# PART B

**Assessment of project changes and response to submissions**

## 4 Environmental Assessment – general submission issues

APPENDIX D

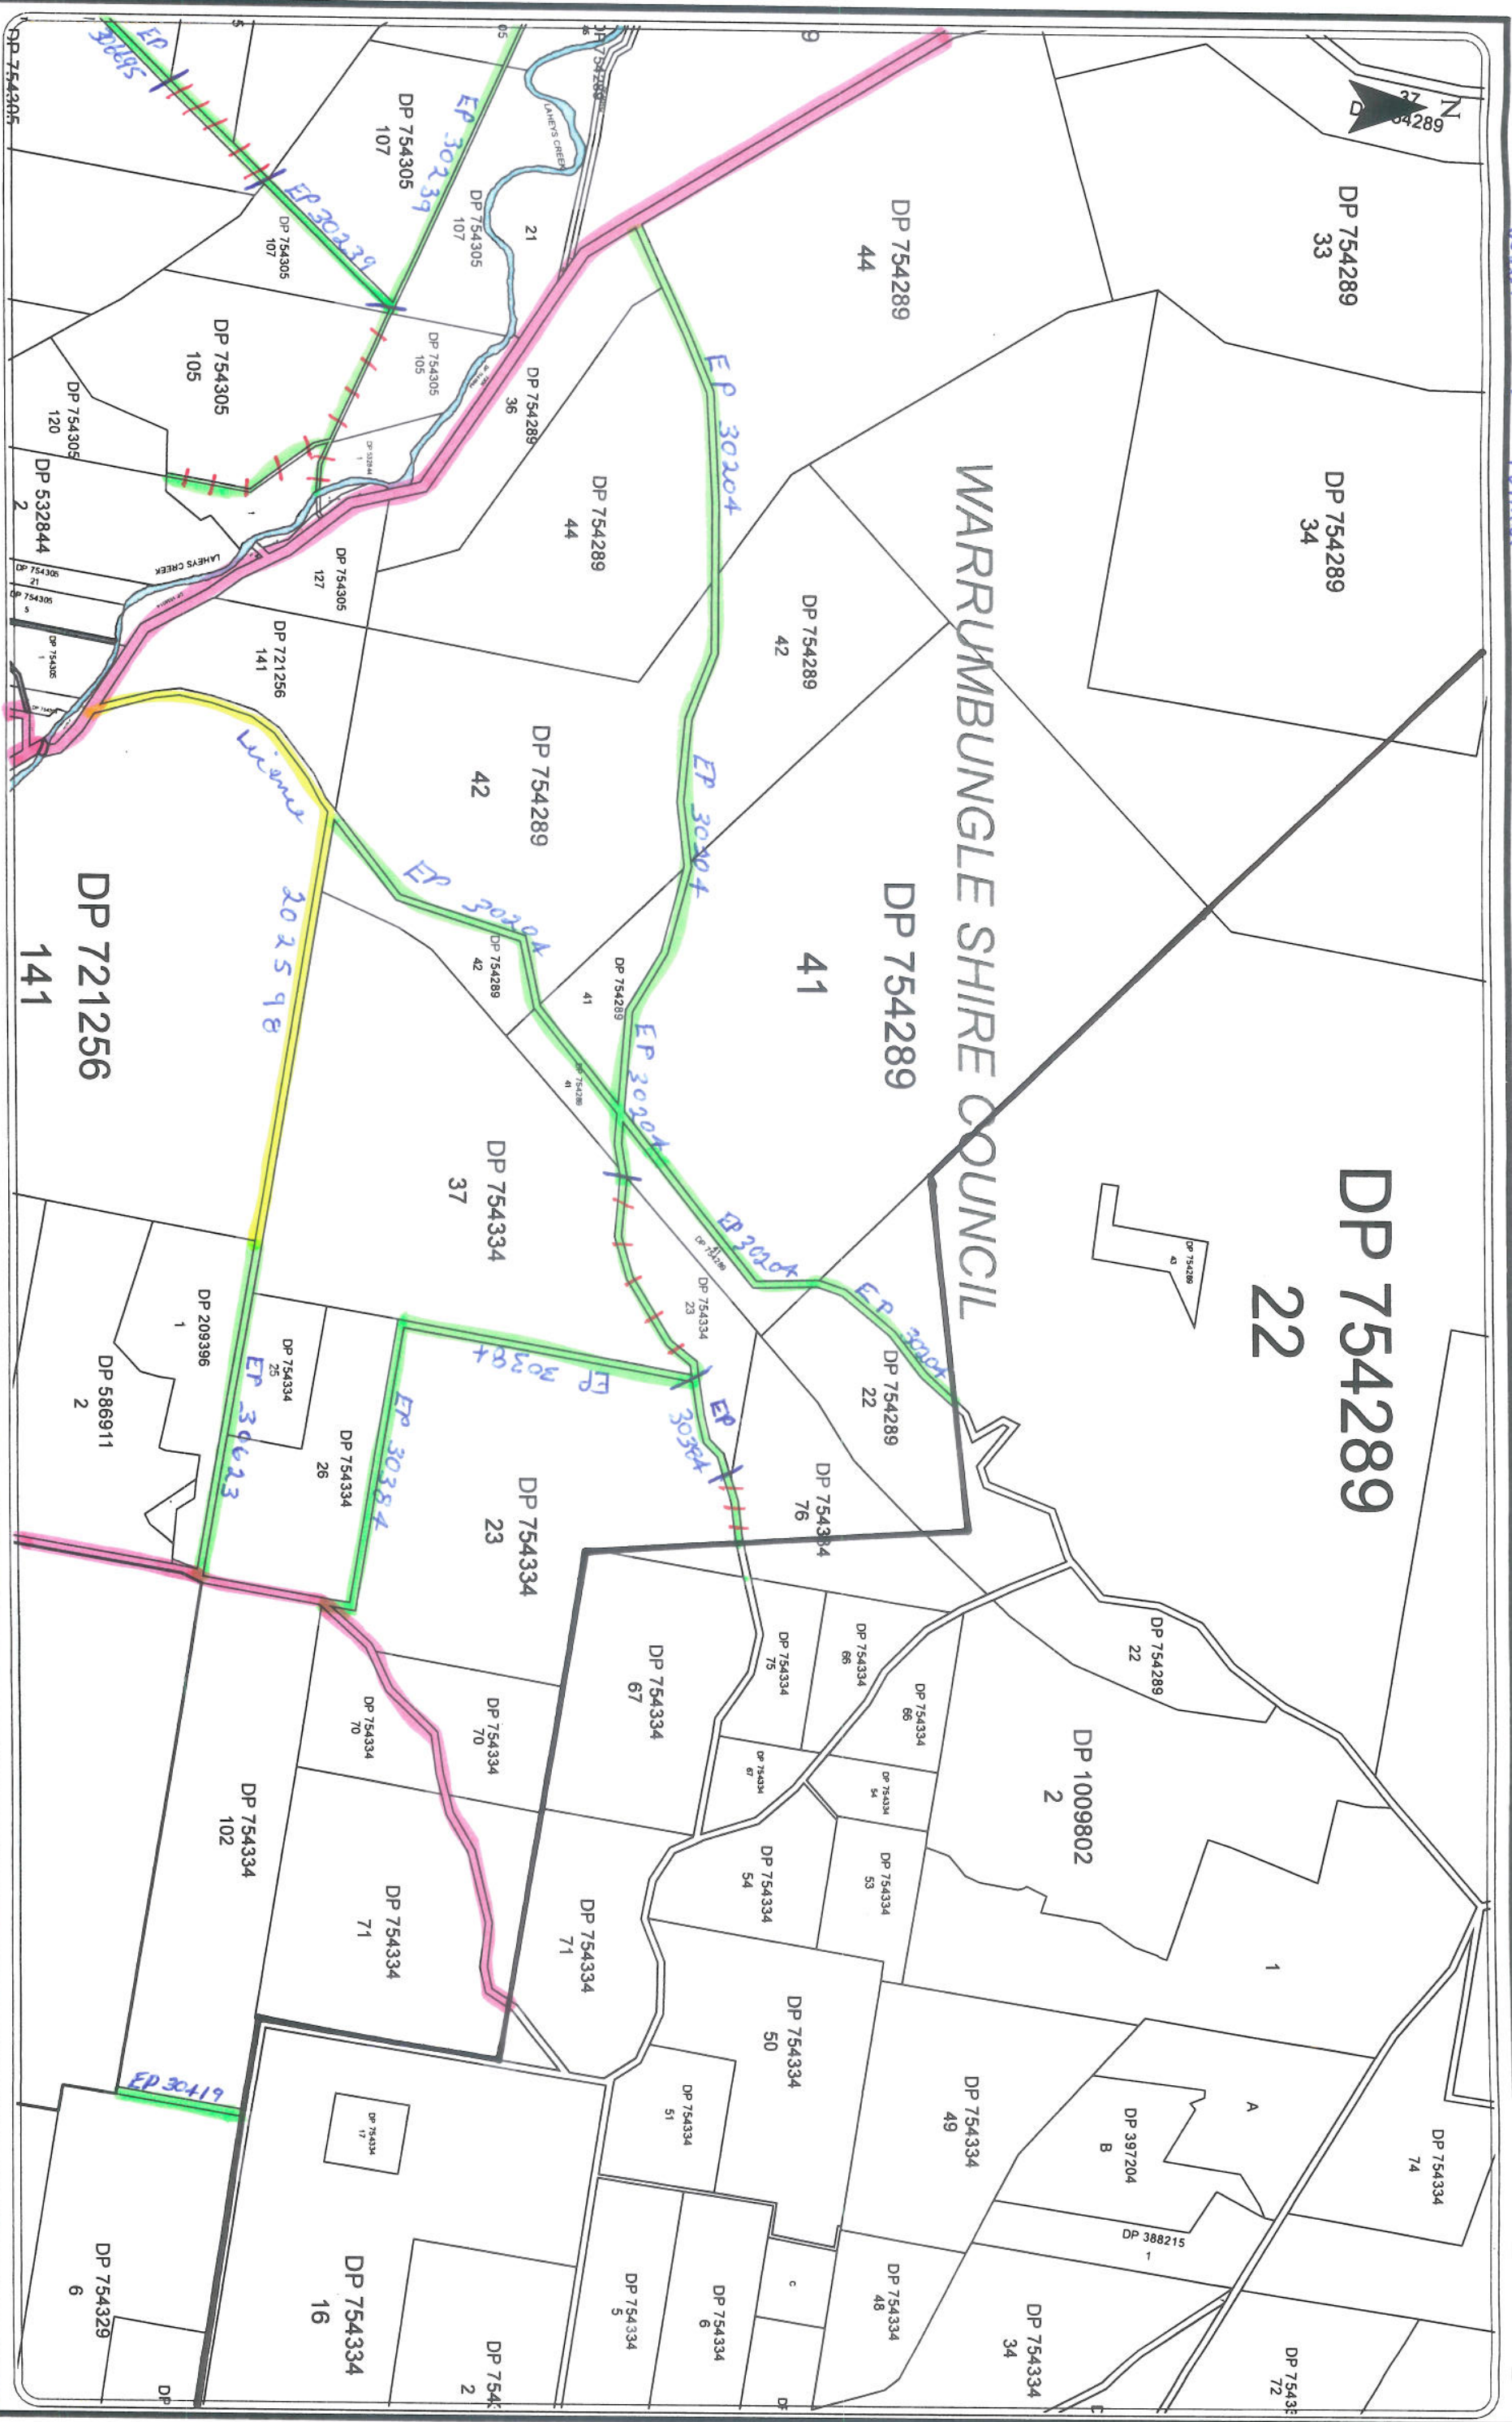
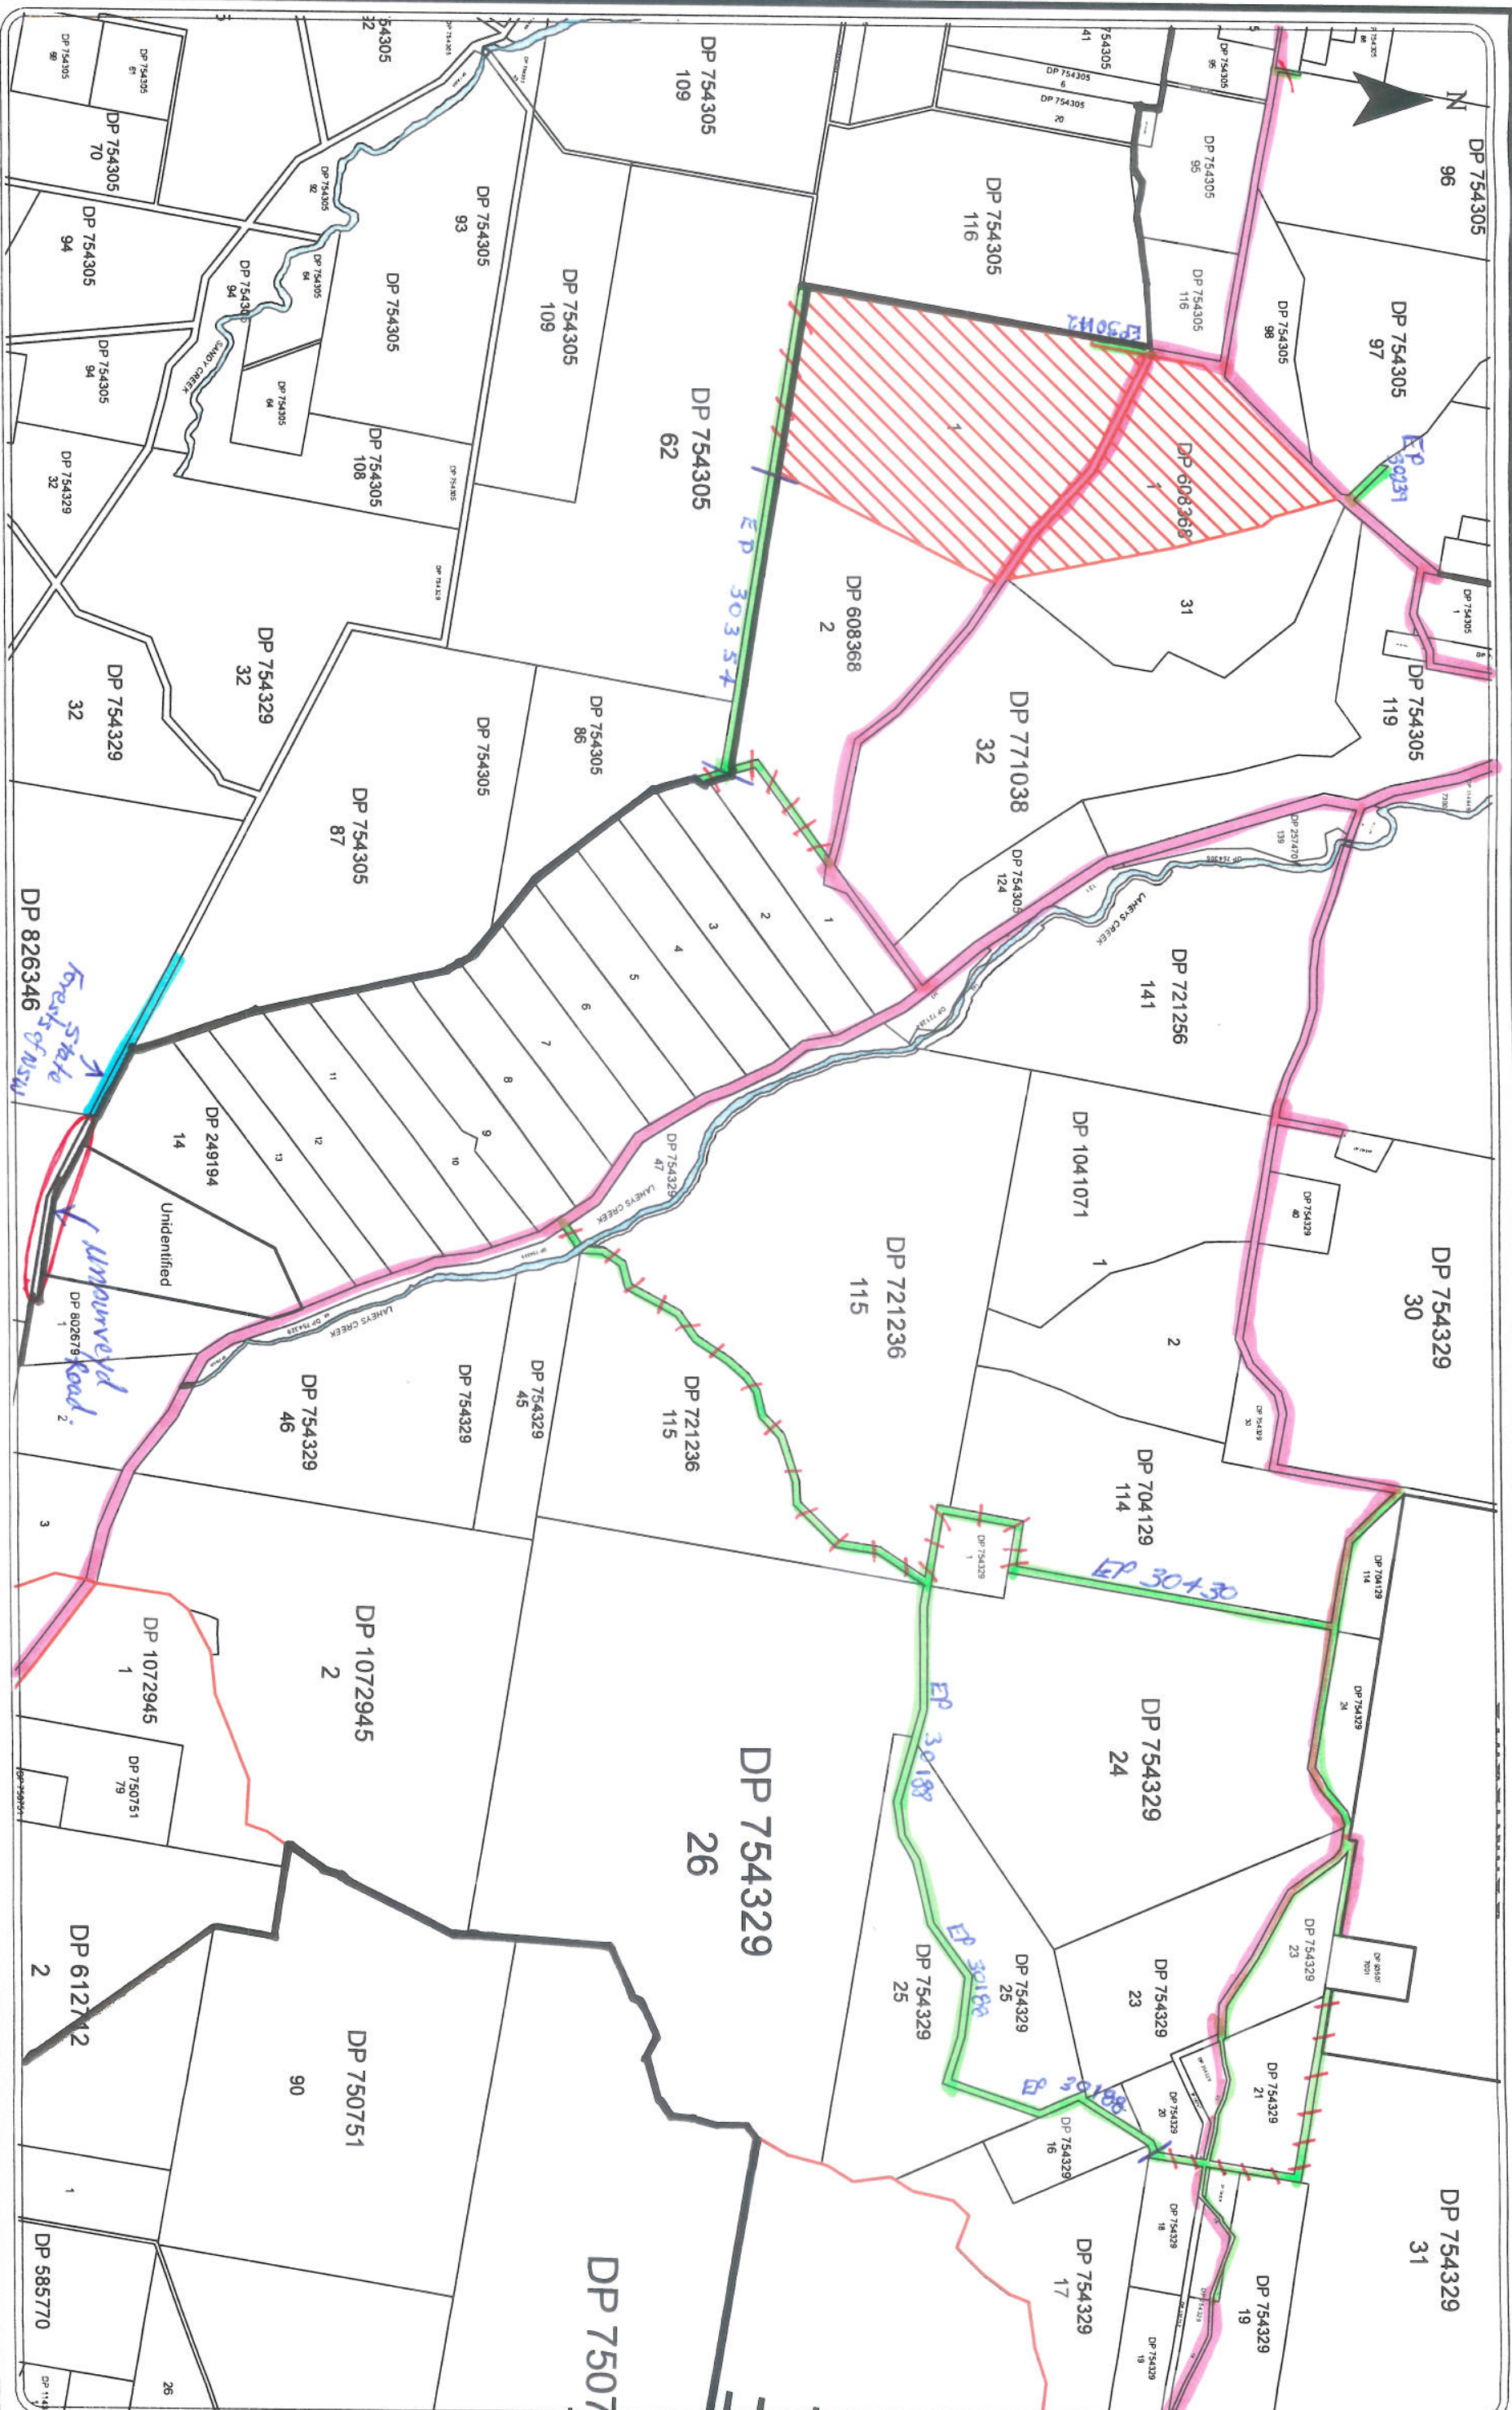
Crown Lands (part of the DPI) comments there are a number of Crown (and council) roads located within the mining area and the proponent will need to make applications to close and purchase these roads before any mining works begin. Contact should be made with the Catchments and Lands Division (Crown Lands) for further details and to determine appropriate actions. Crown Lands goes on to comment that there are a number of areas of Crown land as well as a large number of Crown (and council) roads within the Project Application Area (but located outside the mining area). The proponent will need to contact the Catchments & Lands Division (Crown Lands) to obtain the necessary approvals to occupy Crown land and/or to determine appropriate actions to allow any Crown roads to be used for ingress and egress from the mining area.

CHC will apply to buy and close the required Crown and council roads and for ongoing access to Crown land. An updated map of Crown land is provided in Appendix D. CHC does not object to the conditions proposed by Crown Lands but notes that draft project approval conditions are prepared by the DP&I and final project approval conditions are prepared by the PAC where the commission is the determining authority as will be the case for the Project.
